Comments to changes to Planning Application 2021/62/91239/W - 410/412 Birkby Road

Side Elevation

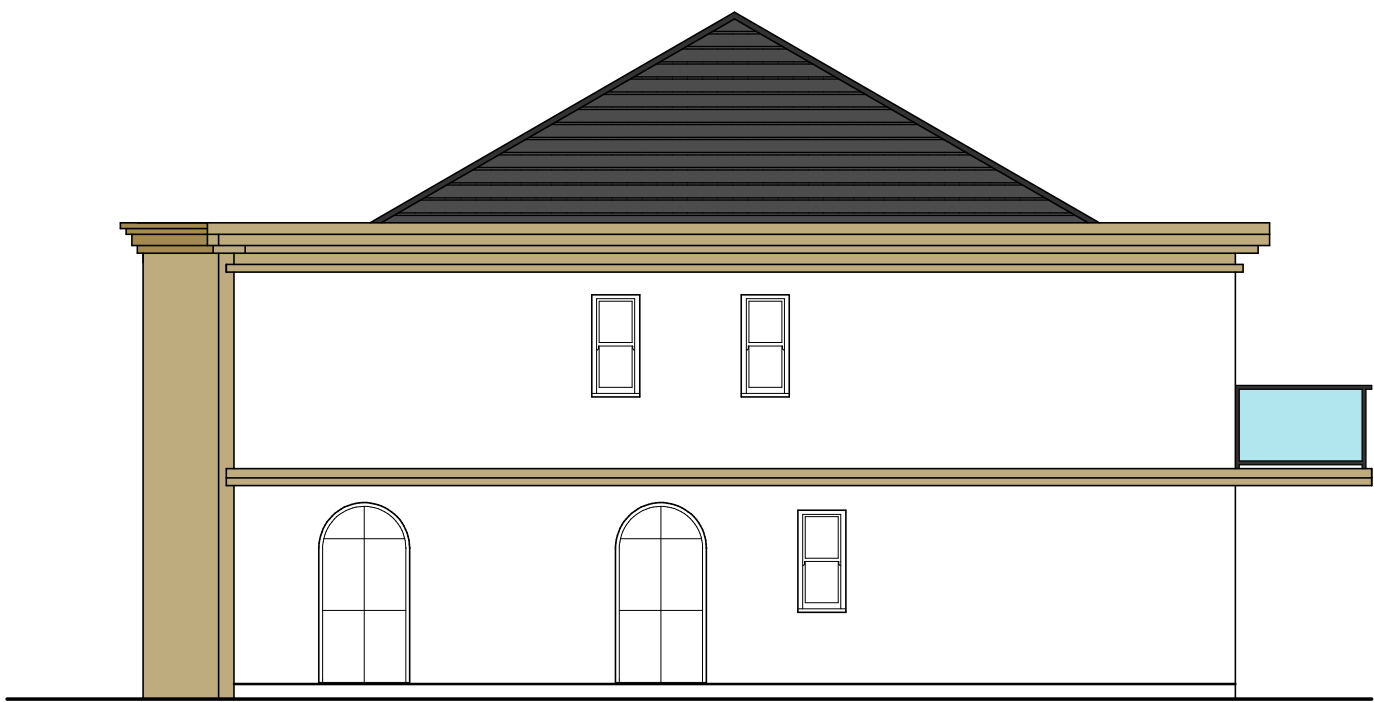
- We note that the side elevation of No 410 has had one large window removed which is a positive move, however that still leaves another two large windows downstairs and the bathroom windows. Bathroom windows we do not object to but the Large windows down stairs still overlook our property and are invasive on our right to privacy.
